From: Jamie Turner
Sent: 08 January 2019 15:25
To: William Simcock <William.Simcock@kirklees.gov.uk>
Subject: 2018/93687 Cliff Road, Holmfirth

BLOCK PLAN Scale :- 1/200th

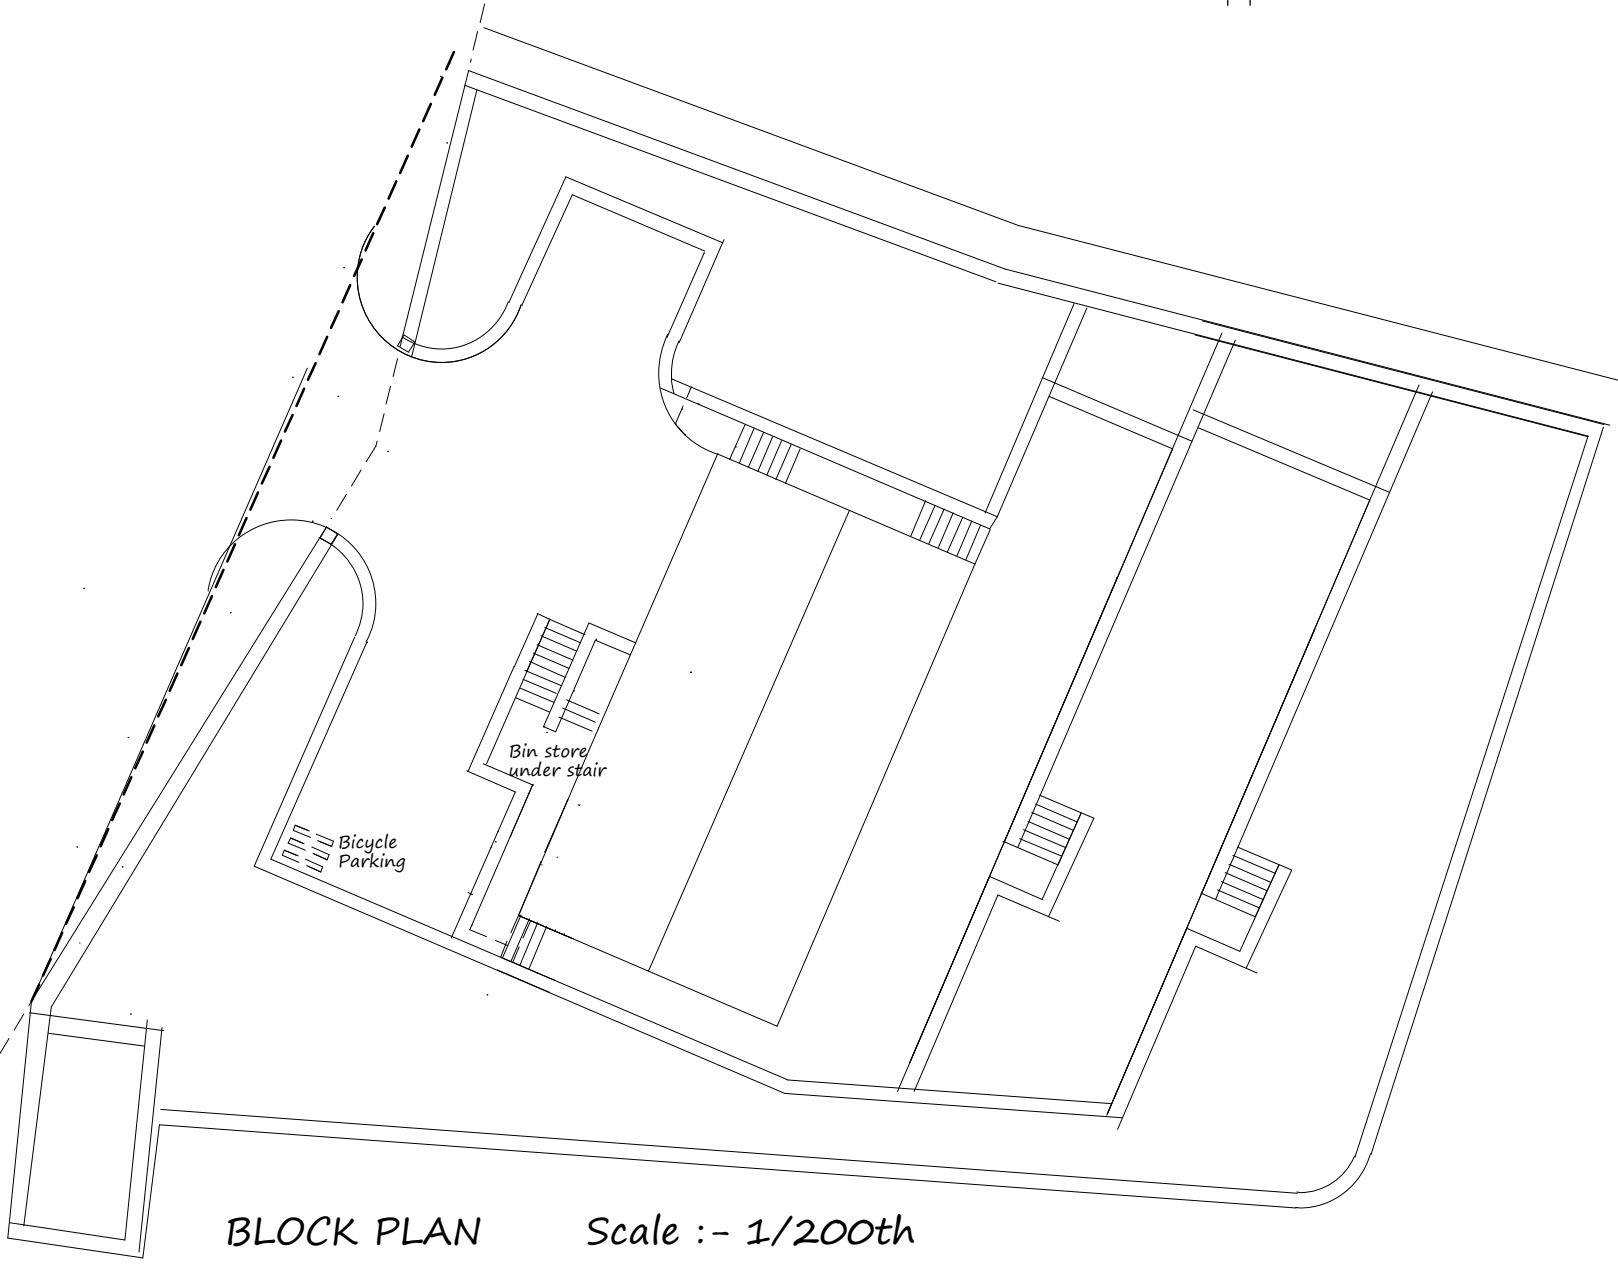
Further to my formal comments on this application, although an independent speed survey would usually be required to justify visibility splays below those set out in Manual for Streets, given the traffic speeds observed on visits to the site, I feel this is unnecessary in this instance and the scheme is acceptable from a highways perspective.

Prior to the development being brought into use, the approved vehicle parking areas shall be surfaced and drained in accordance with the Communities and Local Government; and Environment Agencies 'Guidance on the permeable surfacing of front gardens (parking areas)' published 13th May 2009 (ISBN 9781409804864) as amended or superseded; and thereafter retained throughout the lifetime of the development.
